# New Catherine Field Primary School Modification 1

State Significant Development Modification Assessment (SSD-9477-MOD-1)

October 2020

CATHERINE FIELD PRIMARY SCHOOL
NEW HIGH QUALITY CLASSROOMS
DRAWING NAME
RETAINING WALL ELEVATIONS
- SHEET 02

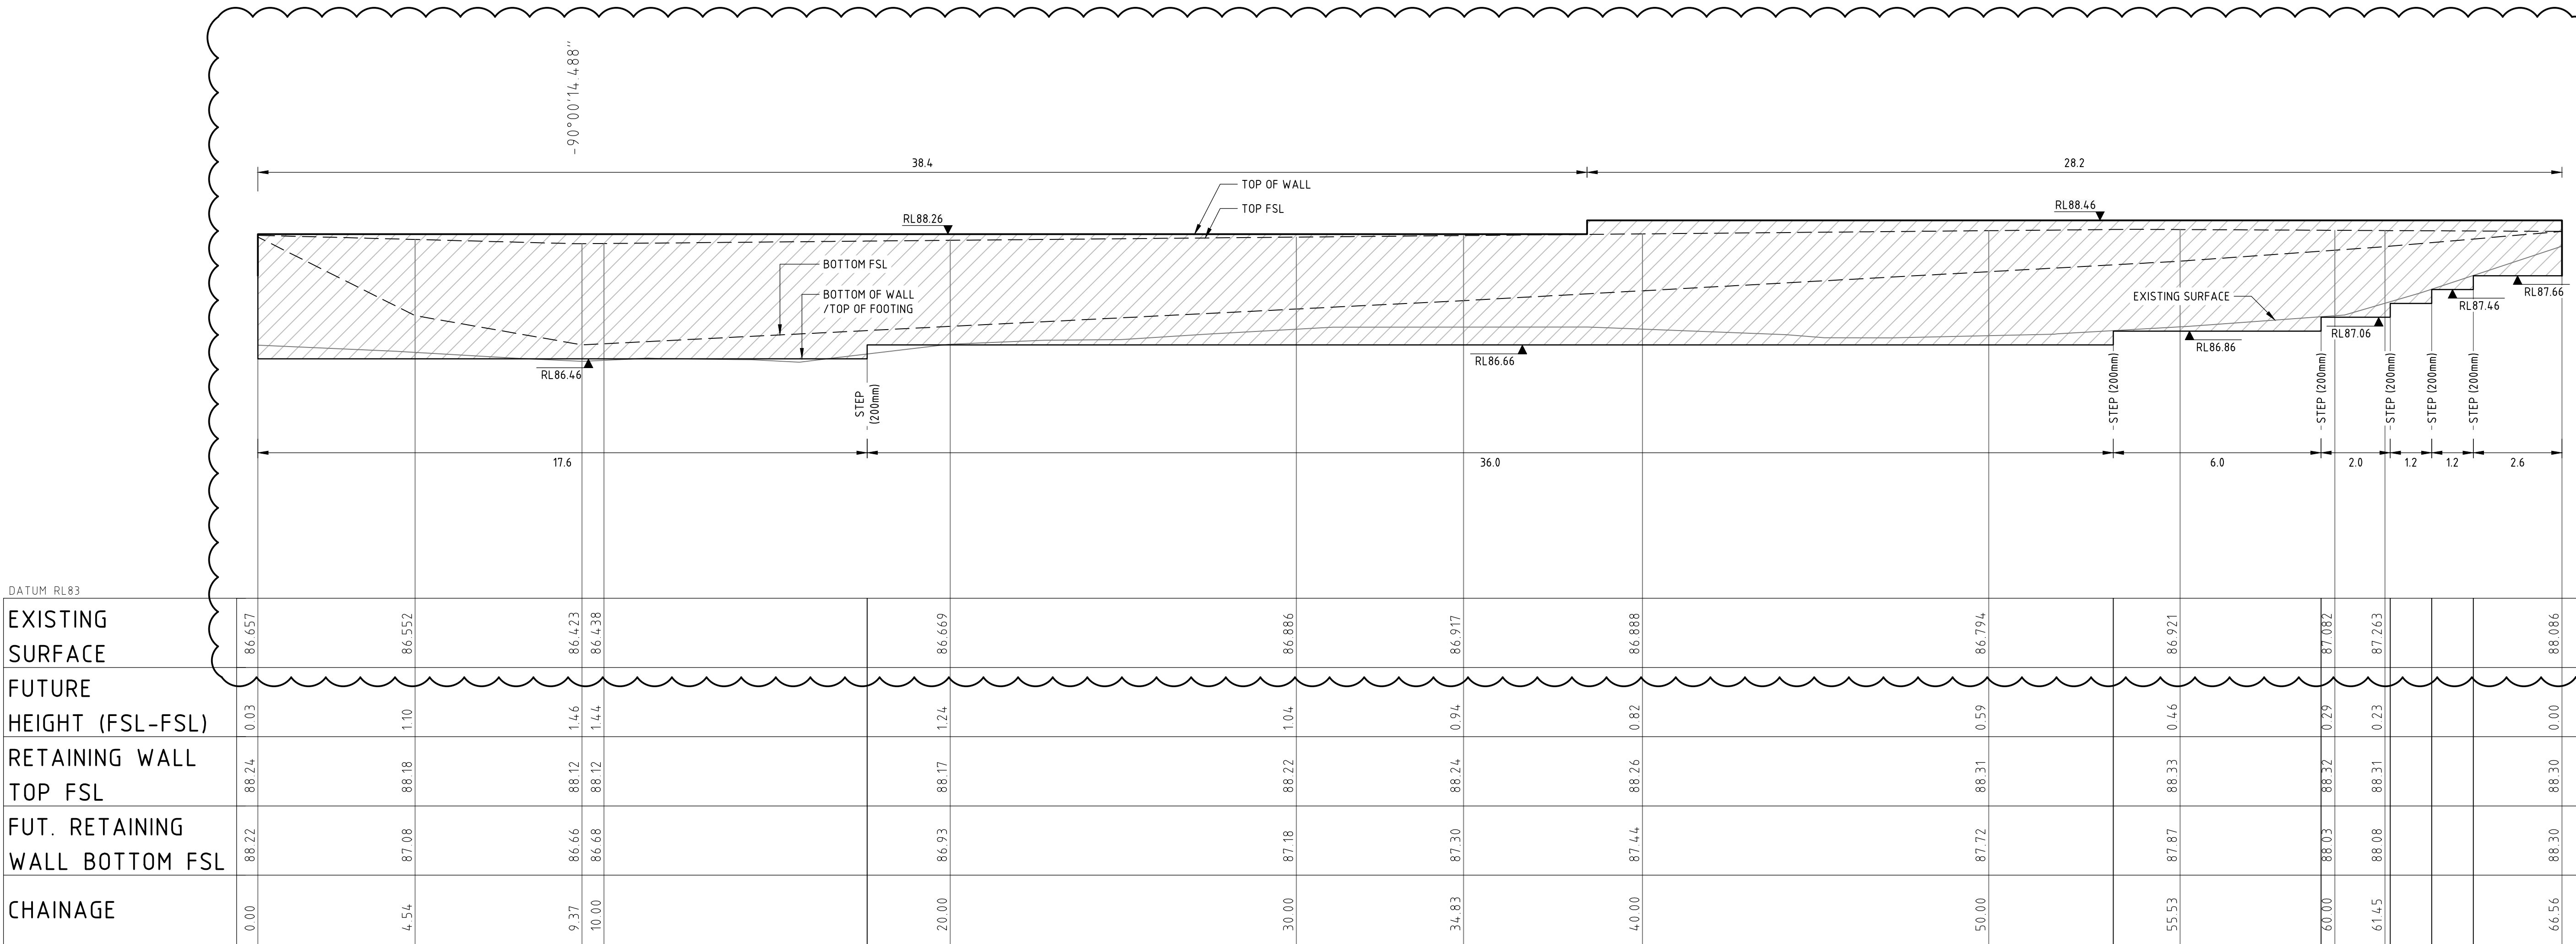
- that it did not object to the proposed operational readiness work subject to the controls proposed by the Applicant and the provision of on-site parking arrangements.
- the retaining wall should be revised to be consistent with the location of the wall as depicted in the further revised site plan submitted in SSD-9477-Mod-2.
- details of the material of the wall should be provided. Sandstone was recommended.
- a balustrade may be needed at the top of the wall depending on its height to comply with the Building Code of Australia.
- a standard condition of consent should be imposed requiring the retaining wall to comply with standard design requirements as follows:

- a) retaining walls shall be designed and certified by a suitably qualified structural engineer;*
- b) retaining walls in cut shall be constructed a minimum of 300mm from any property boundary to ensure all associated drainage and backfill remain wholly within the subject property;*

- c) retaining walls in fill shall be constructed to ensure all associated drainage and backfill remain wholly within the subject property;*
- d) adequate provisions shall be made for surface and subsurface drainage of retaining walls and all water collected shall be diverted to, and connect to, a stormwater disposal system within the property boundaries;*

- e) retaining walls shall not be erected within drainage easements;*
- f) retaining walls shall not be erected in any other easement present on the land without the approval of the relevant authority benefited; and*

- g) retaining walls are to be finished with anti-graffiti coating.*

- the use of blockwork for the wall is appropriate given that it will only be visible on a short-term basis. A recommended condition of consent requires the wall to be painted if proposals for the land to the north of the wall were to change such that the wall would be permanently visible.

- the development is required to be constructed in accordance with the Building Code of Australia. In addition, the approved site plan shows that a 2.1m high palisade fence is to be built along the top of the wall on the site boundary which would act as a safety barrier at the level change.

- Council's recommended condition is accepted except for the requirement for graffiti protection given the cost of doing so and the expected short-term exposure of the wall. Instead, a condition has been recommended that graffiti be removed with 24 hours and that graffiti protection be provided if proposals for the land to the north of the wall were to change such that the wall would be permanently exposed.

- on-site parking for operational readiness work is not possible given construction works continue on site. However, alternative arrangements are proposed to avoid impacts on the local road network, including for staff to park at nearby schools with shared transport to the site.
- the layout of the retaining wall proposed in SSD-9477-Mod-2 will be reviewed to ensure that it reflects the layout intended.
- the retaining wall would be made of blockwork given that the wall is intended to be temporary visible.
- it is expected that a balustrade would not be required as the land to the north of the site is expected to be developed (and the level change removed) prior to completion of the car park.
- the proposal would comply with the requirements of the condition recommended by Council.

- revision of the approved plans listed in condition A2 to incorporate the revised site plan and elevation of the retaining wall.
- inclusion of Council's recommended condition as revised above to omit the requirement for graffiti protection.
- inclusion of a condition requiring graffiti to be removed within 24 hours.
- inclusion of a condition requiring the wall to be painted and graffiti protection be applied if the wall remained exposed six months after the commencement of operation.

DRAWING NAME  
**SITE PLAN**

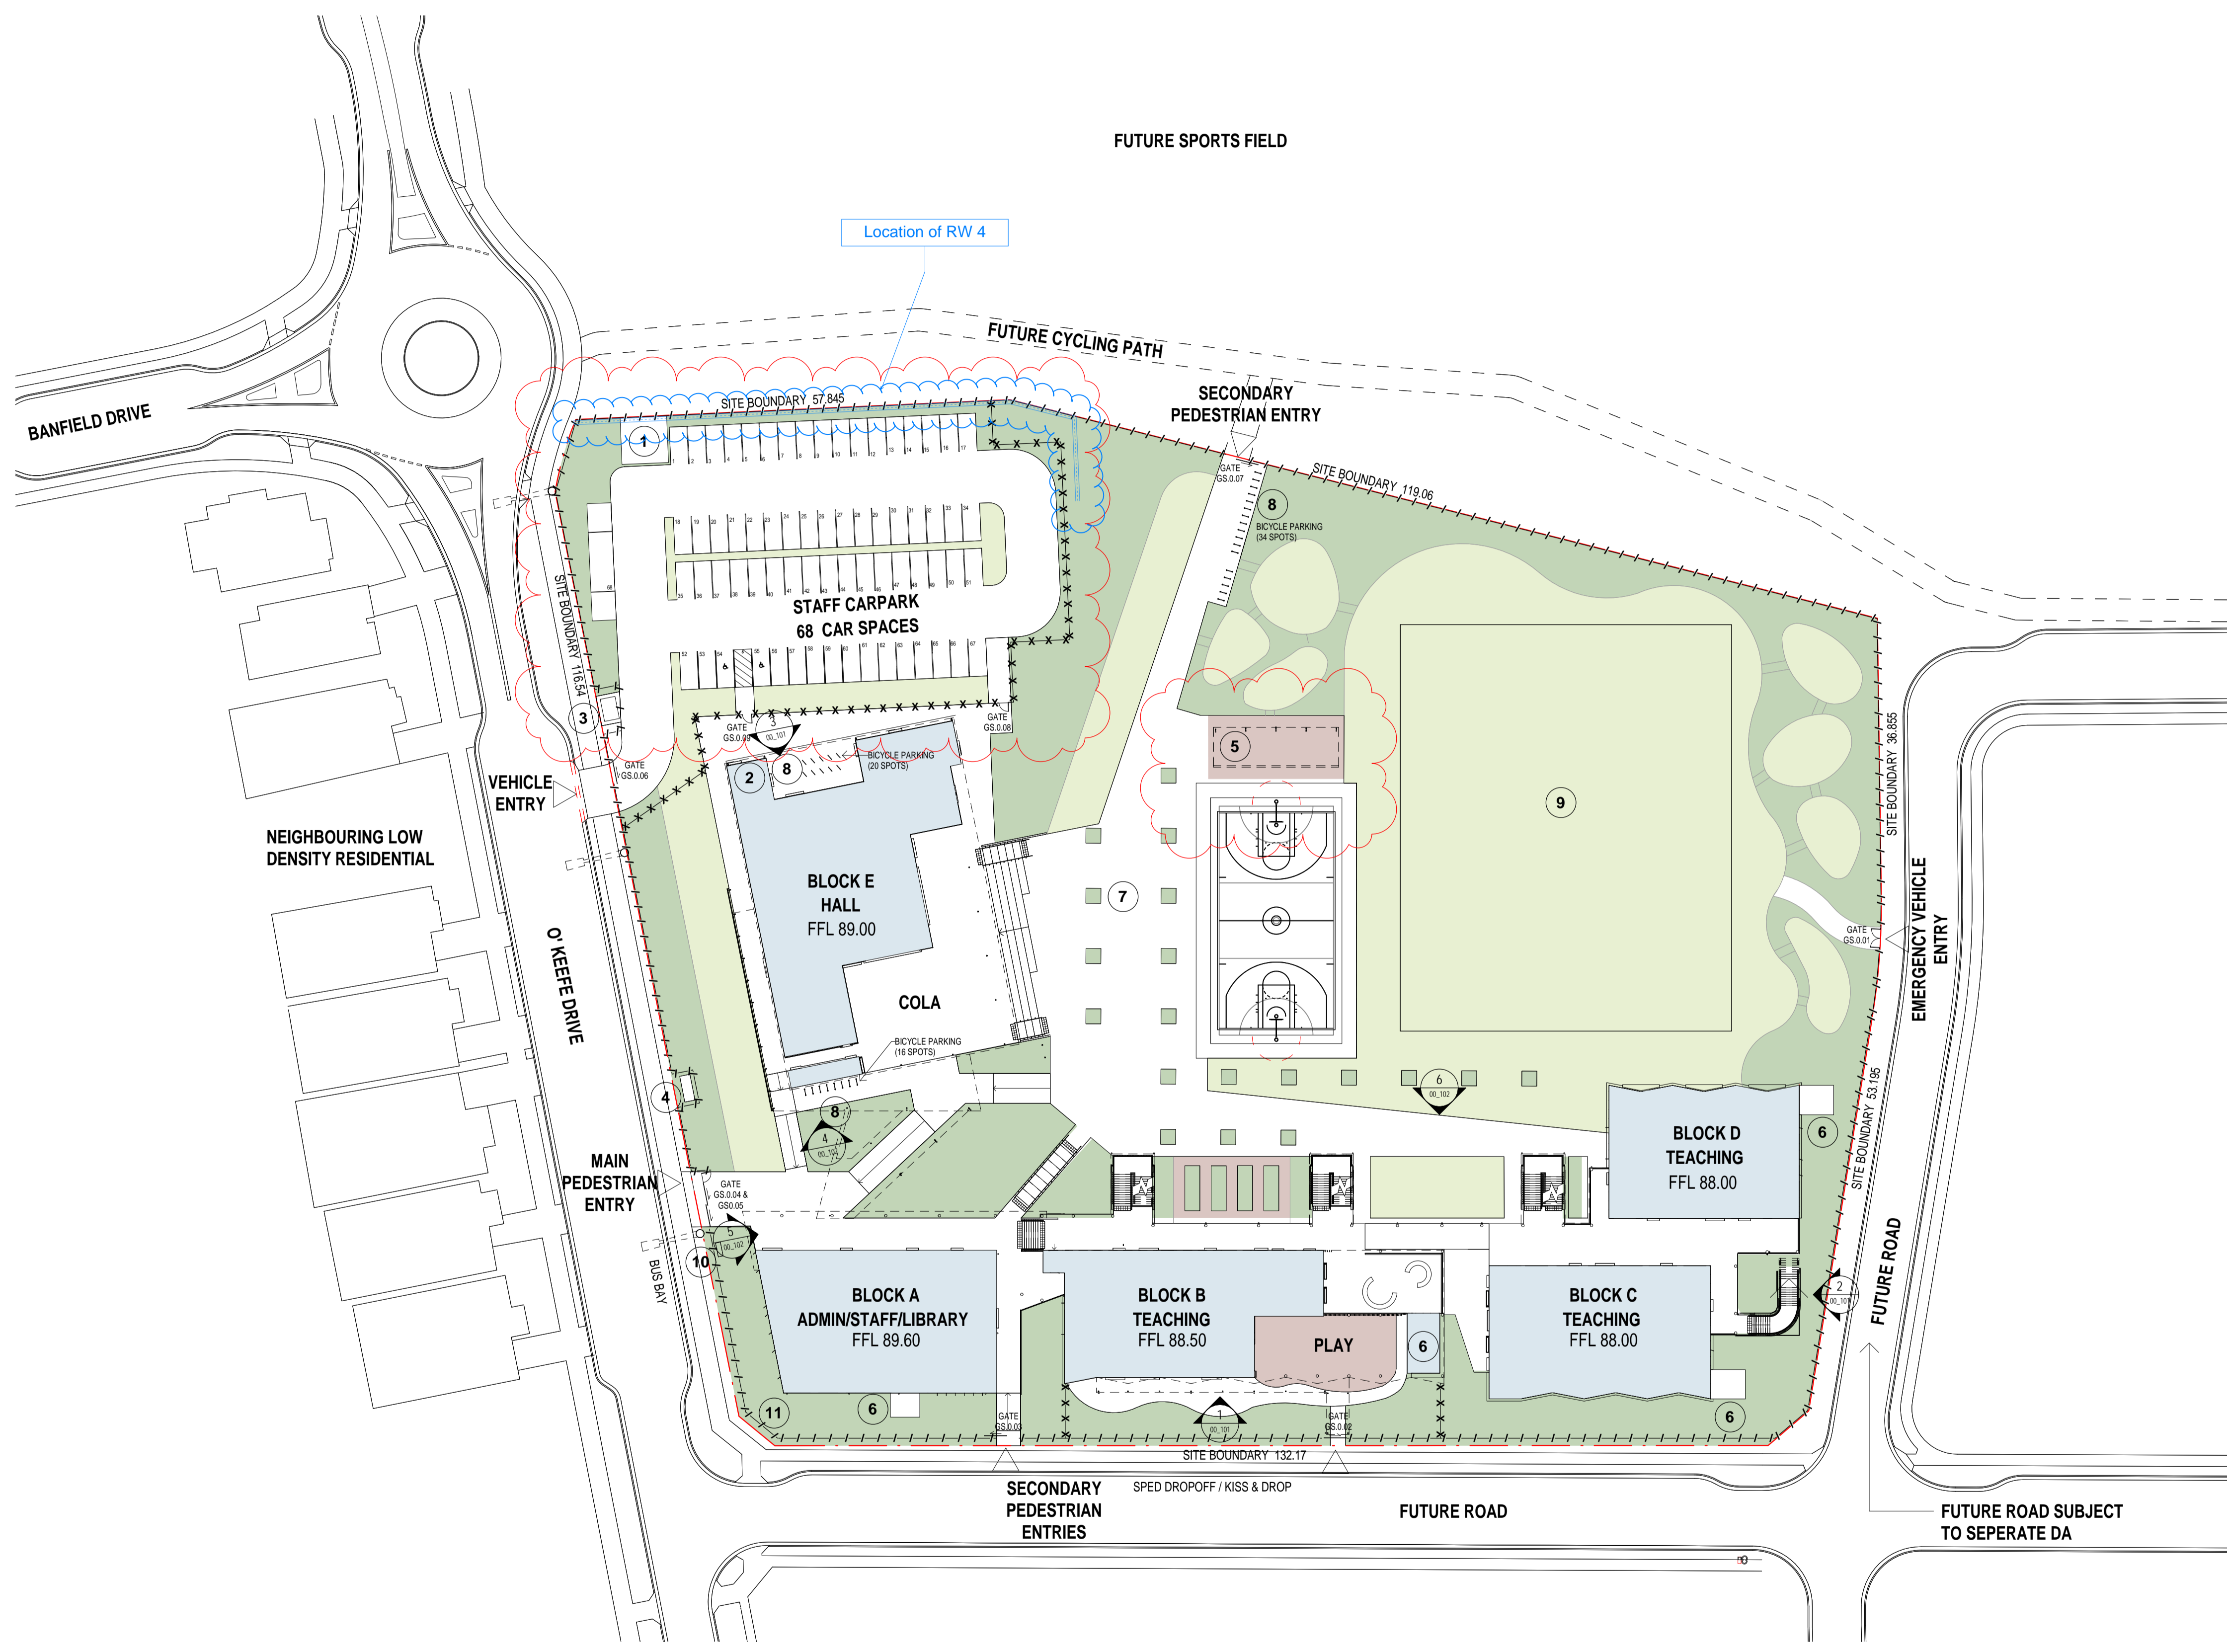
- any discrepancies between plans submitted Mod-1 and Mod-2 can be resolved prior to determination of Mod-2.
